**Proposed Himley Village North West Bicester
Middleton Stoney Road Bicester**

**23/00170/REM and
23/00214/REM**

Proposal: Reserved Matters Application pursuant to outline planning permission 14/02121/OUT for Phase 1A (infrastructure comprising two junctions to provide vehicular and pedestrian access into the site from Middleton Stoney Road and two initial sections of internal road) along with the partial compliance of conditions 12 (Building for Life 12), 16 (means of vehicular access), 17 (means of pedestrian/cycle links) and 19 (detailed surface water drainage scheme) for Phase 1A.

TITLE
MIDDLETON STONEY ROAD,
SECONDARY ROAD JUNCTION.
GENERAL ARRANGEMENT
SHEET 2

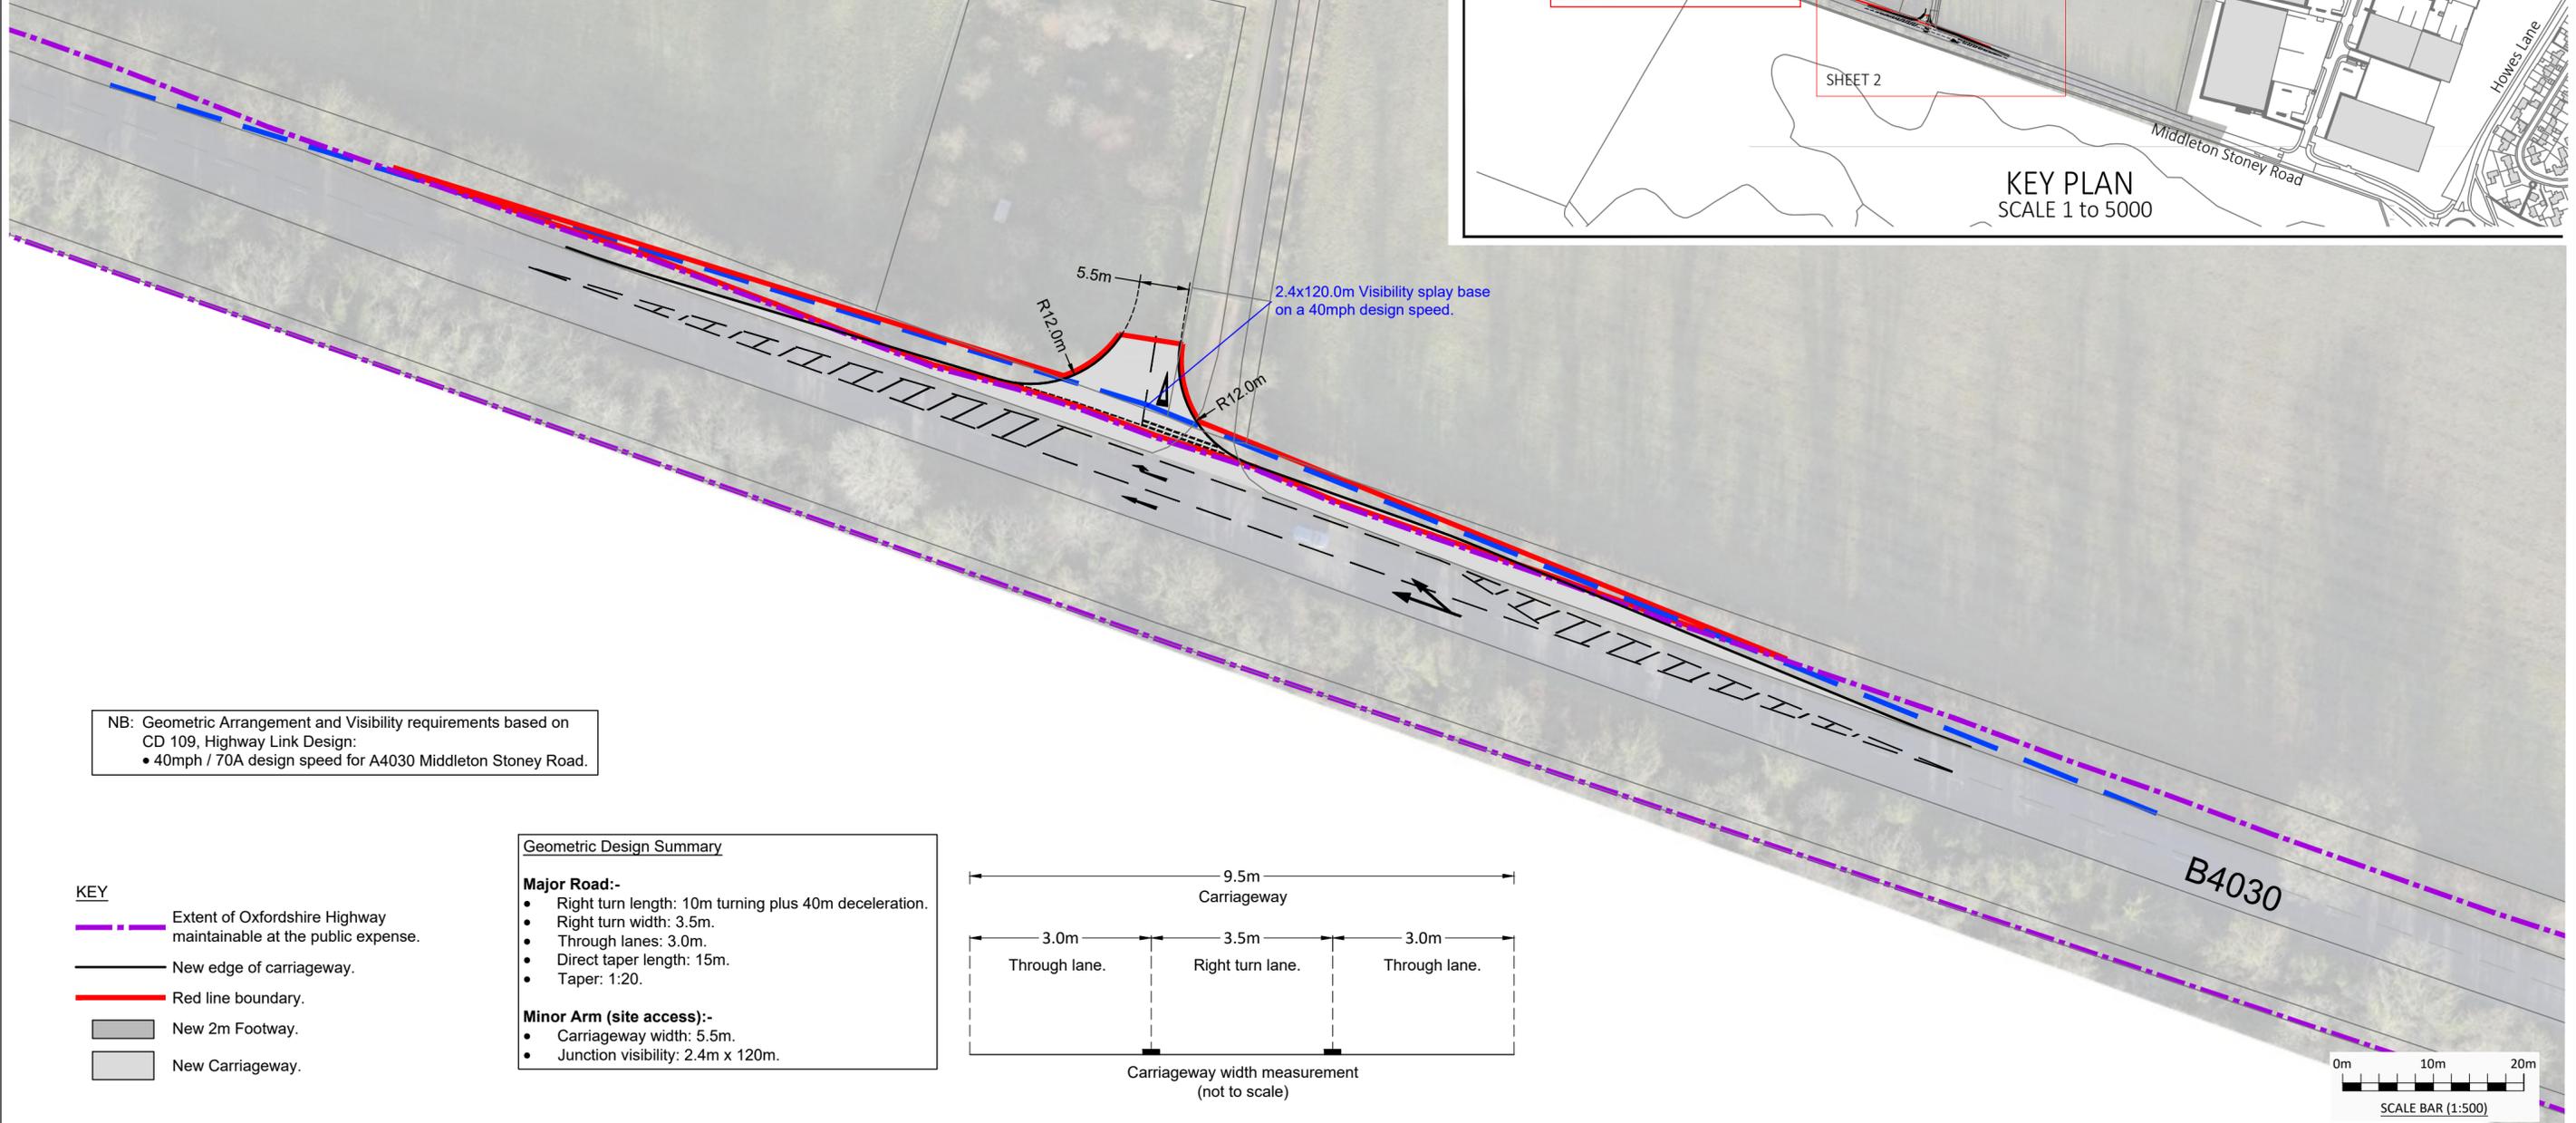
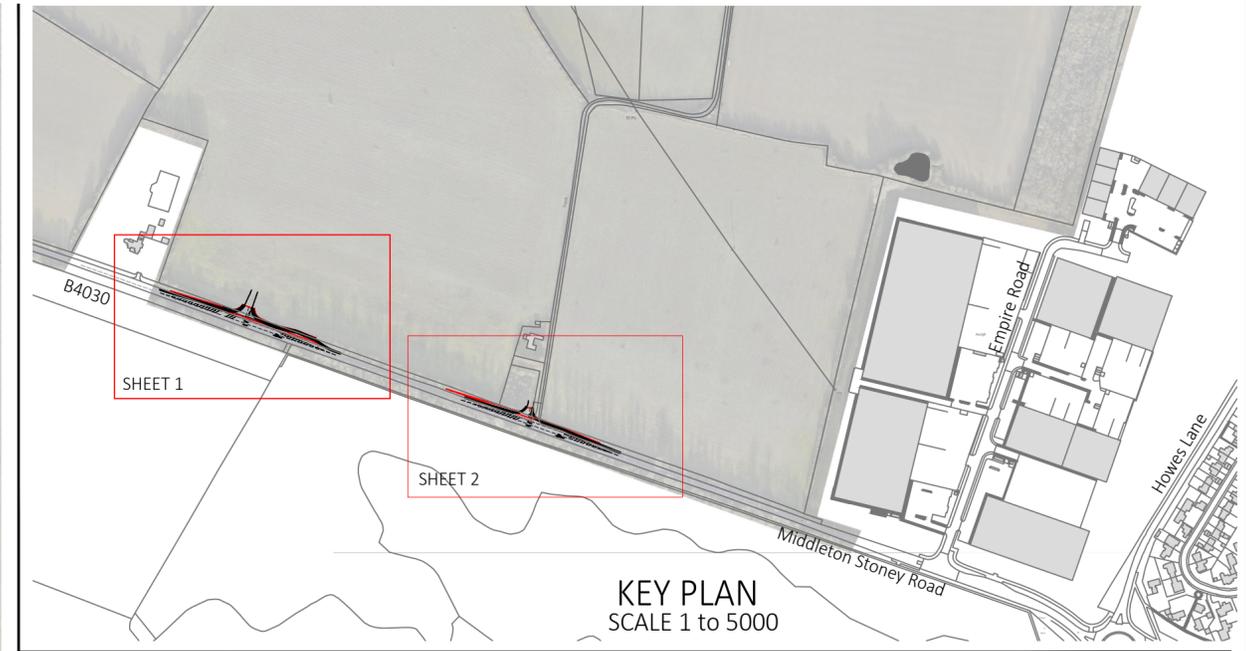
Local Highways – No objection. They originally objected to the application on the grounds that the secondary access was not sufficiently wide to allow 2 buses to pass. They have subsequently removed this objection on the grounds that the bus service would not need to use the secondary road/access even for a temporary period and that adequate public transport provision could be achieved for an interim period from the service on Middleton Stoney Road prior to buses entering the site via the primary access road and the adjoining Axis J9 development. Confirm that they have no objections relating to partial compliance with conditions 16 and 17.
